## 6 Groundwater

### 6.2 Response to submissions

Figure 5.7 Predicted groundwater levels 20 years after end of mining

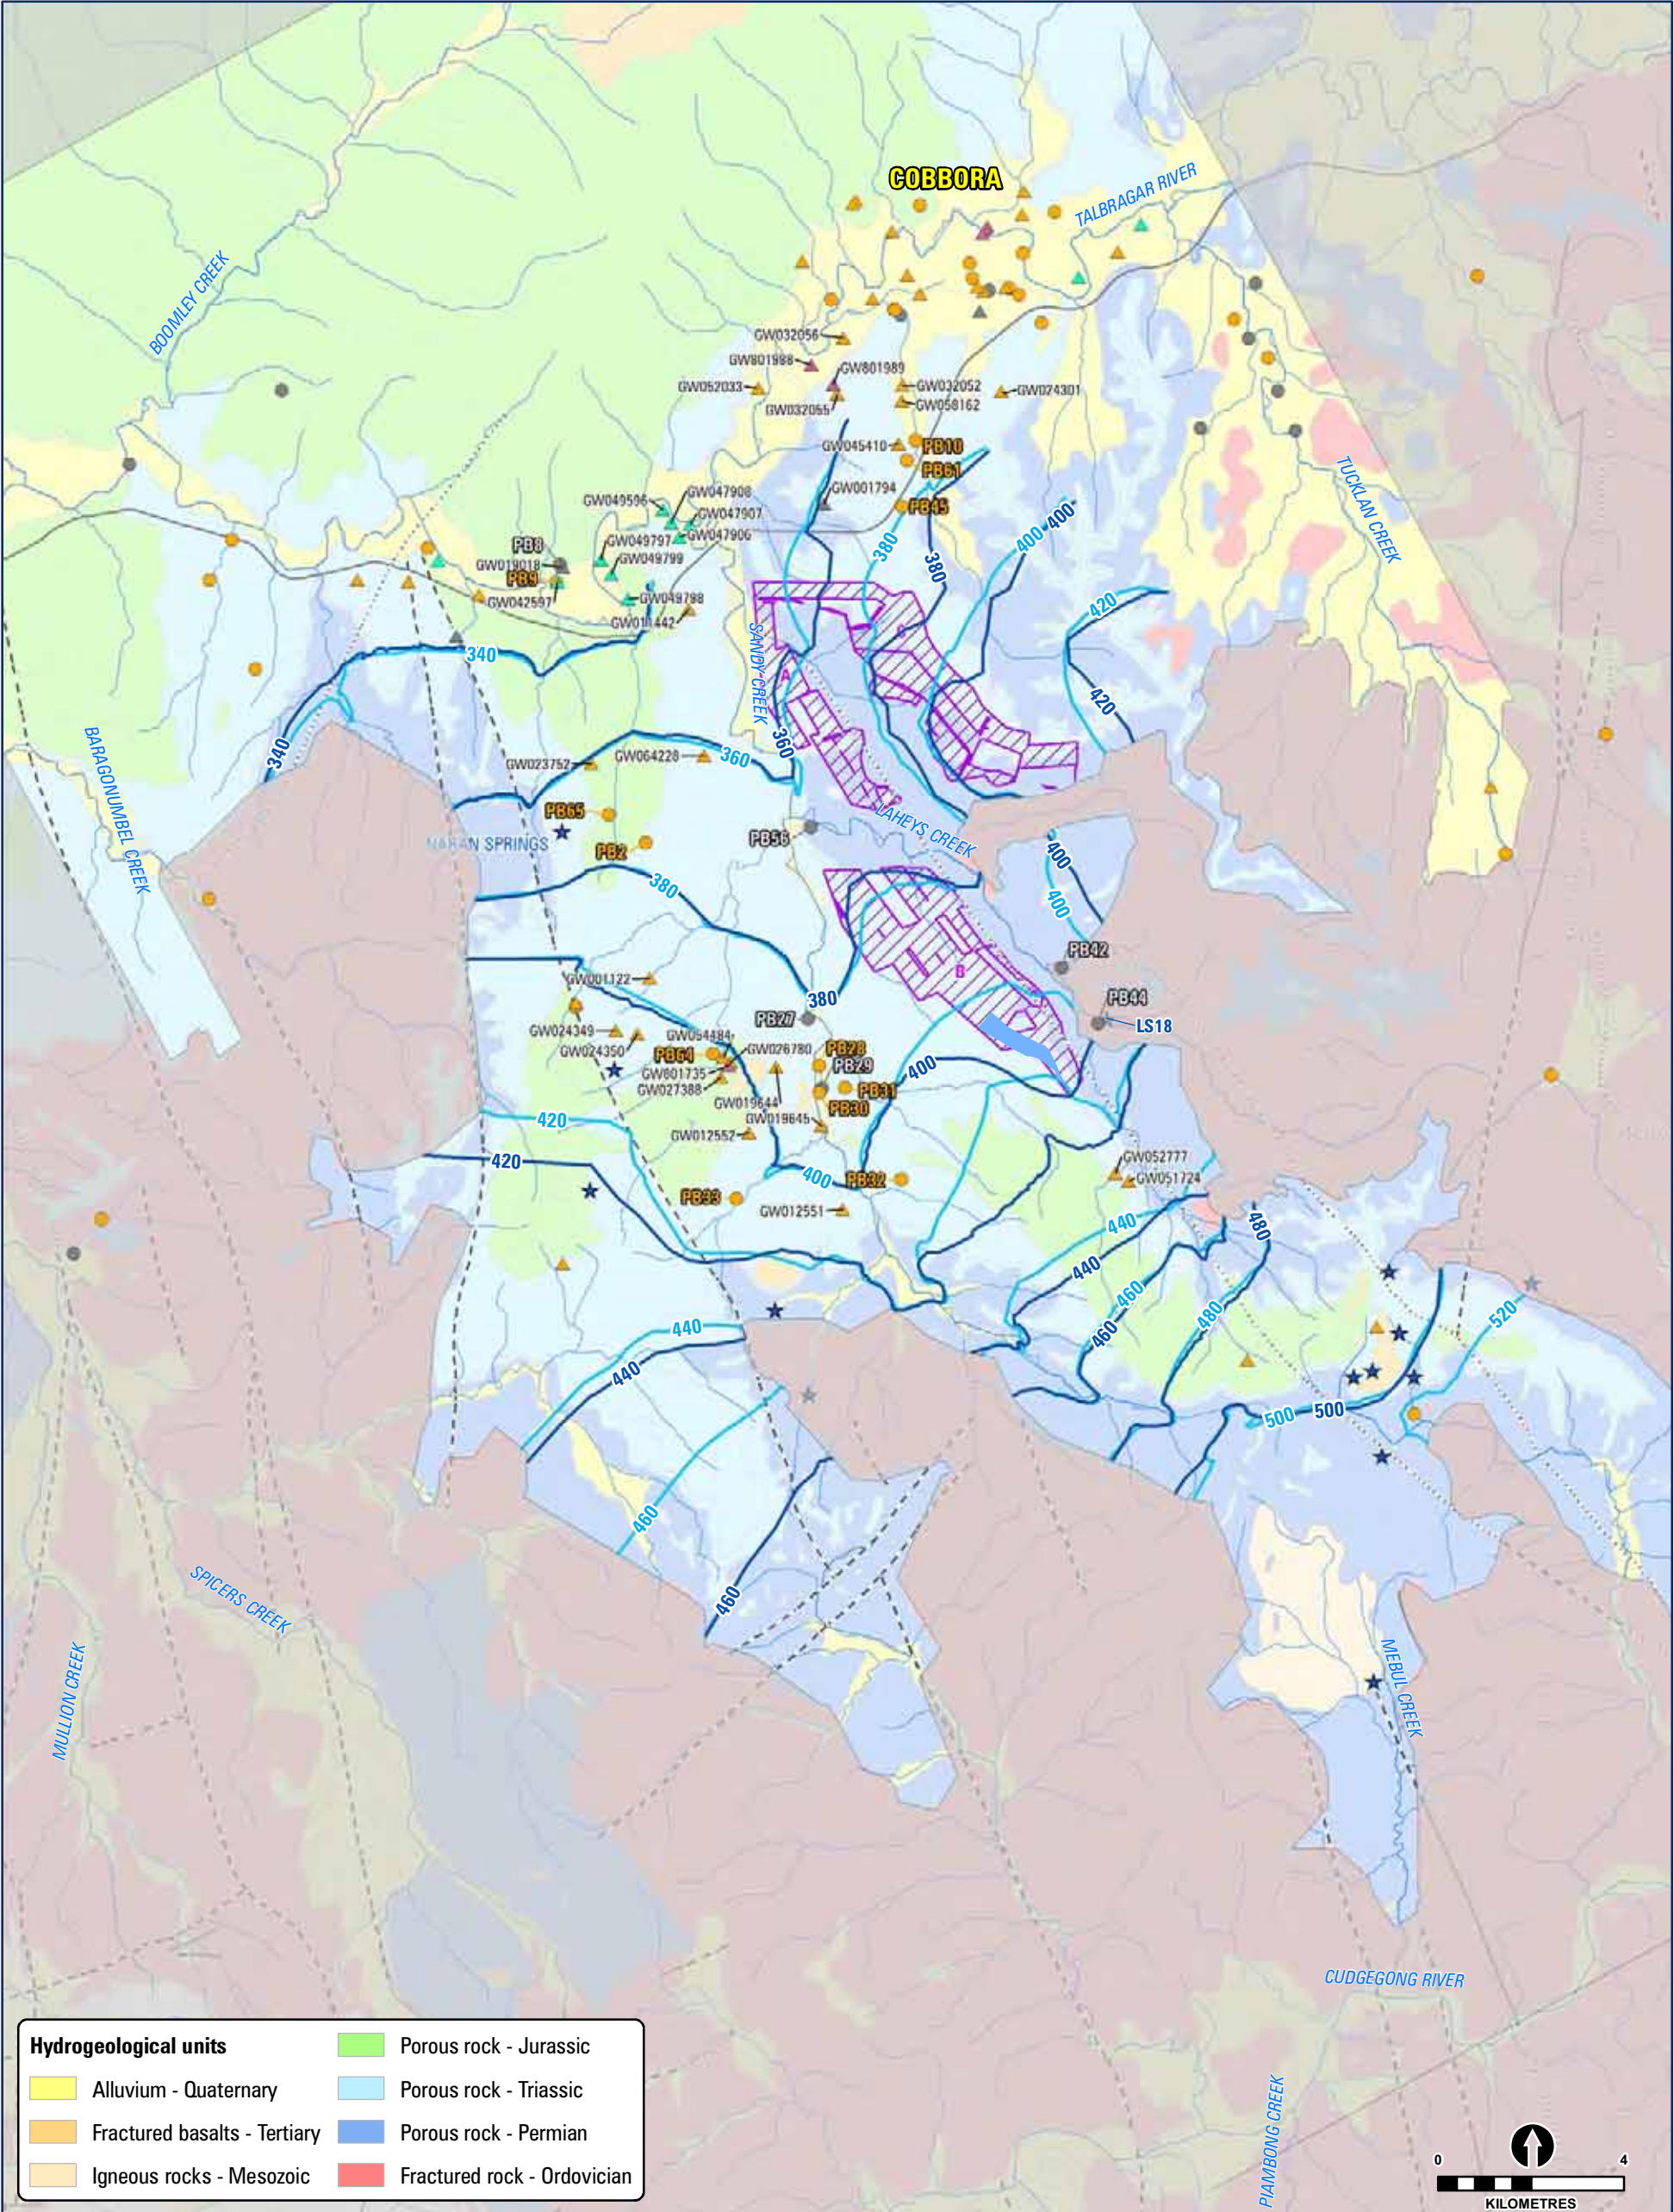
- that there is an inadequate assessment of the groundwater recovery levels, including no post-mining reduction contour maps, and inadequate information presented on cumulative storage loss and net reduction in river flows to 2080;
- that post-mining aquifer drawdown contours should be provided for the Permian and Triassic aquifers and for overlying alluvial aquifers; and
- that further explanation is required for the statement that CHC will commit to backfilling the void to a level that will minimise evaporative losses, particularly if this is to a level where evapotranspiration becomes extinct, and the costs and benefits of this process.

The updated groundwater assessment provides predicted cumulative storage losses and river losses to 2085 (Figure 5.2 in Appendix H 'Groundwater model technical report' in Appendix E. Residual groundwater drawdown contour maps are also provided for 20 years (Figure 5.7A and B) and 100 years (Figure 5.8A and B) after the end of mining. The drawdown contours are provided for the Ulan Coal Seams (Permian), where the impacts are predicted to be greatest, and for the water table aquifer, where groundwater dependent ecosystems have been identified.
